Objection.

I noticed a retrospective planning application for a garden building in my neighbourhood being advertised recently outside the above mentioned dwelling. I note the deadline for submissions states 5th June, however this notice only appeared less than 21 days ago, hence my representation below:

PLAN FROM LEFT SITE

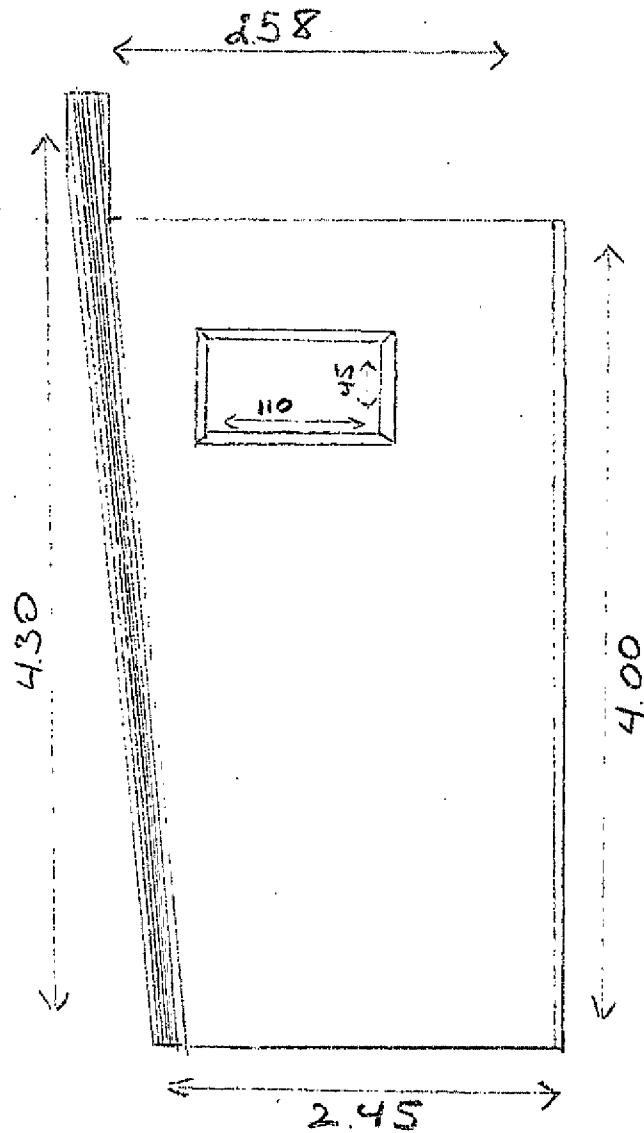
- The side window (less than 1m from the boundary fence) on the north west elevations directly overlooks our and our neighbour's garden, leading to a loss of privacy.

East Front Elevation

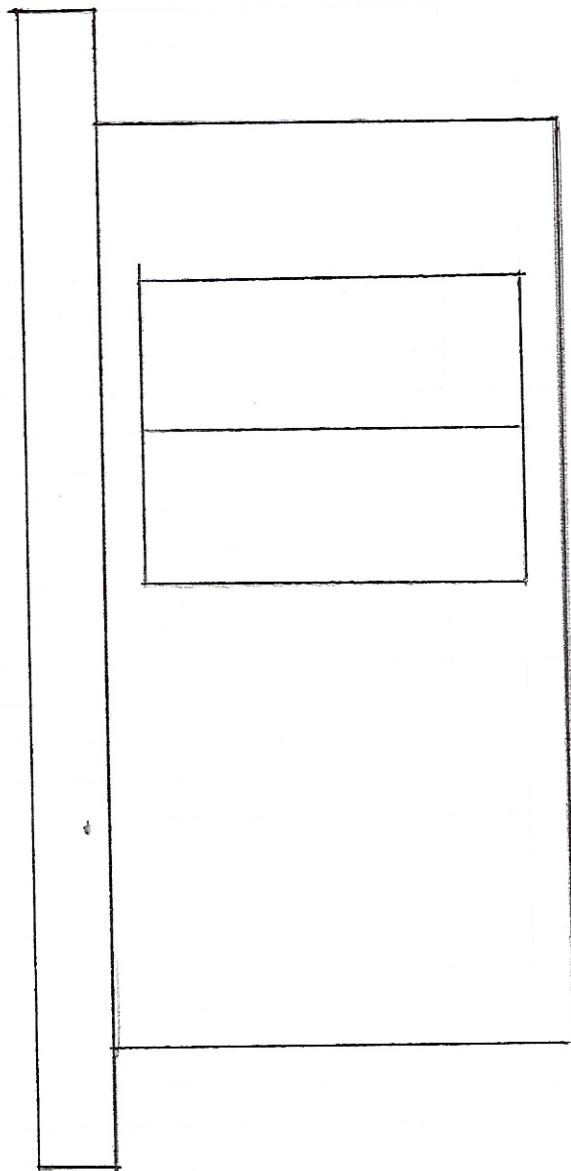
- I don't believe the measurements to be accurate, especially the max. overall eaves height of 2.58m is vastly understated. Together with a floor area approaching 30 m² this building required planning consents and building regulations approval.
